Online Comment

Application	H05-1112-25
Location	CREAM HOUSE CHURCH END FLEET PE12 8NQ
Proposal	Proposed extension

Name	Greg Watkinson
Address	Conservation Officer

ELEVATIONS AS PROPOSED

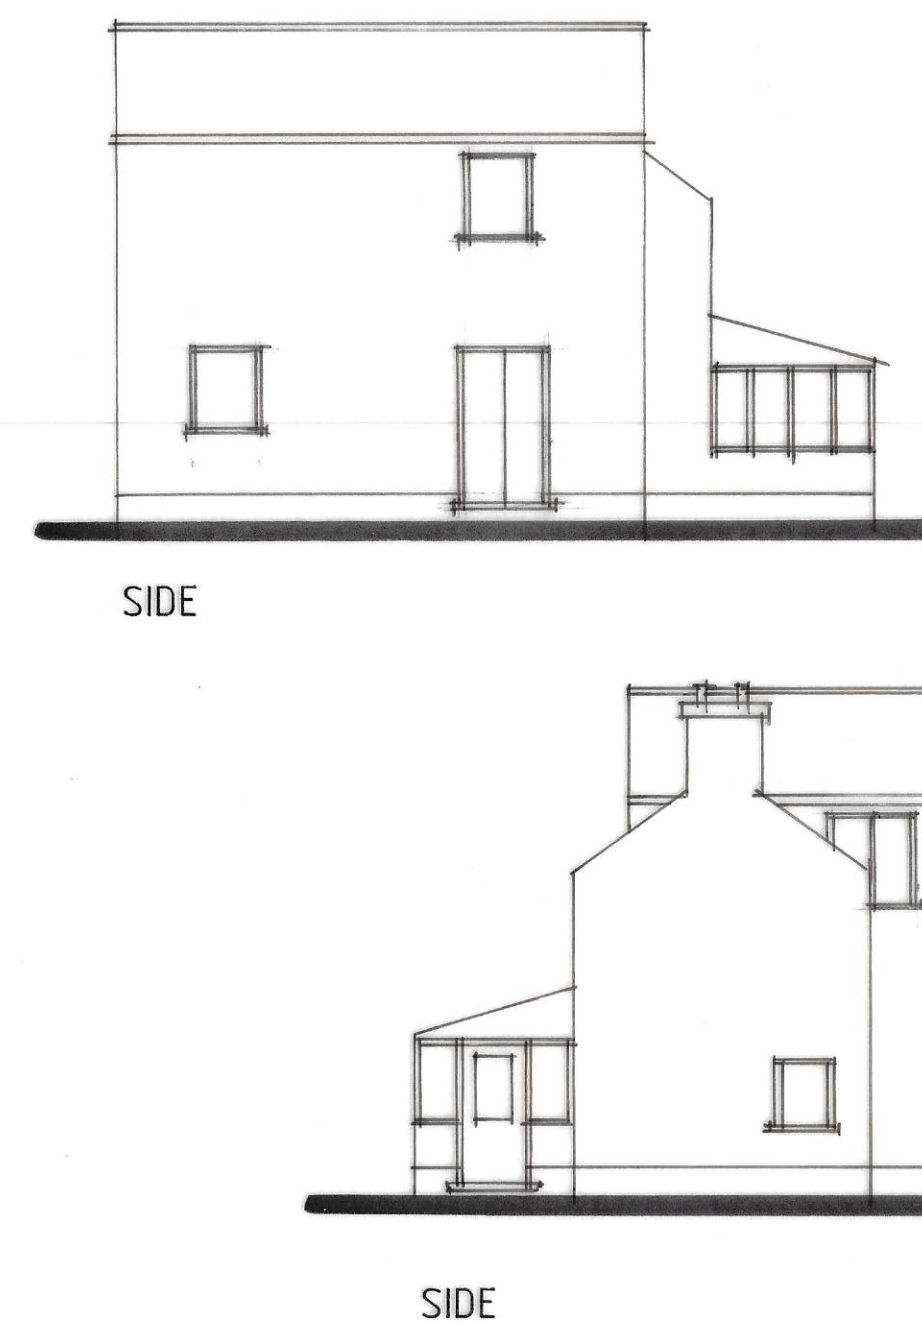
With that said, I have no objections to the proposed development. The glass link proposed is positive in allowing the readability and separation of the old and the new. Whilst in an ideal situation, the height of the proposed extension might be matched to the roof apex of the original dwelling, I do not consider that the development as proposed would bear a material harmful effect upon the setting of the nearby conservation area, provided that any approval is accompanied with suitable conditions; namely ensuring that the materials of external construction are matching to the host dwelling.
